**Application Reference:** 2025/1068

**Site Address:** 4 Longside Way, Pogmoor, Barnsley, S75 2JL

**Introduction:** Erection of a single storey rear extension and installation of render to original dwelling.

**PROPOSED FRONT ELEVATION**  
SCALE 1:100

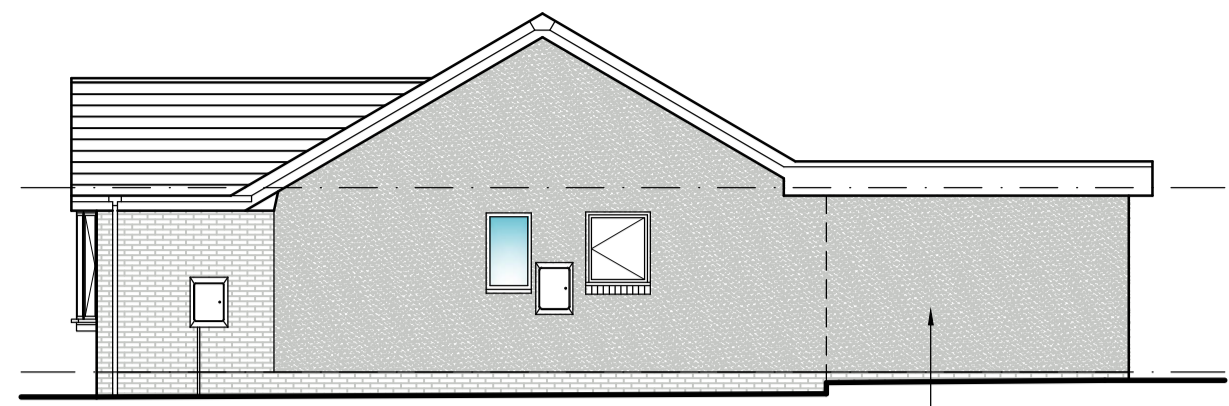
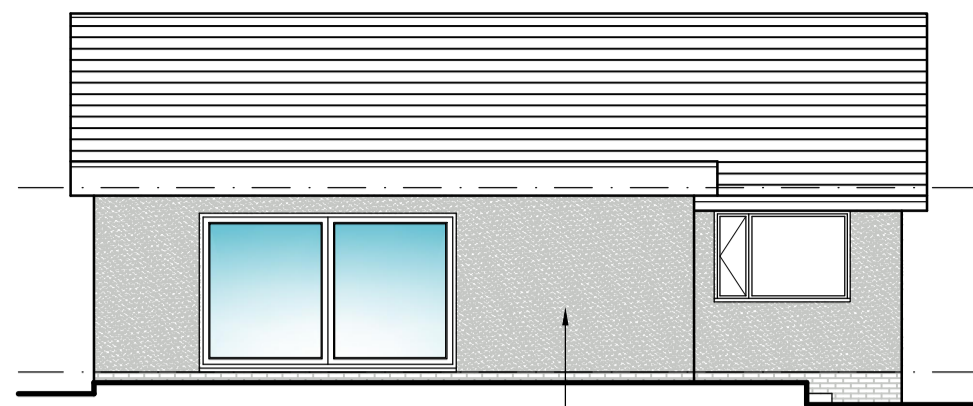
The side elevations of the dwelling are proposed to be Off-White rendered as well as the left side of the front elevation. Although the use of render is not preferred, given there are other small-scale rendered elements to the front elevation of dwellings within the estate, the use of render is considered acceptable on this occasion. Additionally, it is noted the main gable feature of the front elevation maintains its brickwork materials whereas the rendered element would be a relatively small part of the front elevation.

The front elevation is improved by the removal of the existing porch which is constructed from poorly matched glazing and PVC.

It has been necessary to make contact with the applicant to request amendments to remove the proposed render to the front elevation of the dwelling. Amendments were not made given other properties within the street scene provide similar rendered features.

**PROPOSED REAR ELEVATION**  
SCALE 1:100

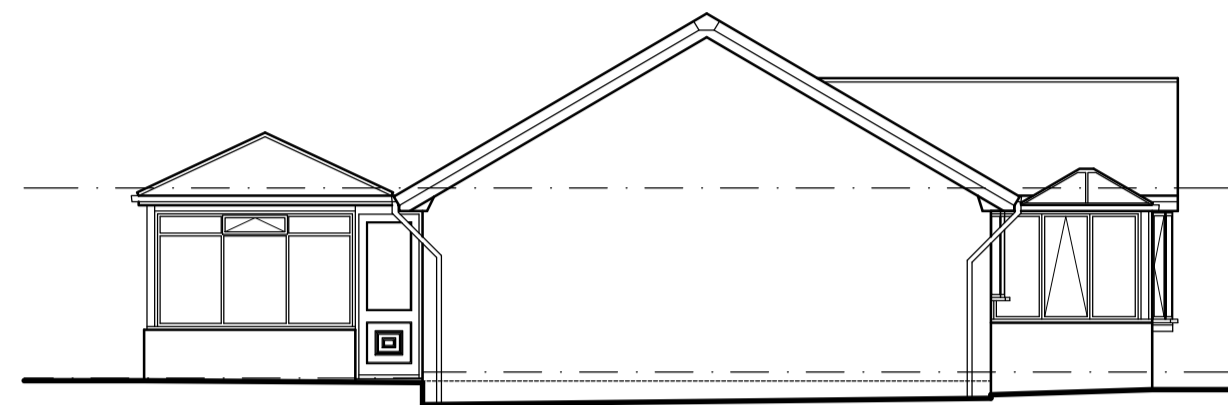
The proposed extension provides an approximate 4 metres projection. The proposed projection would not be too dissimilar to the existing rear extension at the site and in the context of the garden space, is not considered to be out of character with the dwelling and site. It is also acknowledged a proposal of a similar size could be erected under permitted development. The use of a flat roof is not preferred, however given the proposal is to the rear, the proposal would not be impactful on the street scene. Additionally, there is an existing flat roofed garage on site which would match the proposal. The use of render is also not preferred, however given the proposal is to the rear it would not be impactful on the street scene.

The proposed window servicing an en-suite and the proposed window servicing the W.C will be conditioned to be obscured glazing in order to protect the privacy of both the applicant and neighbours
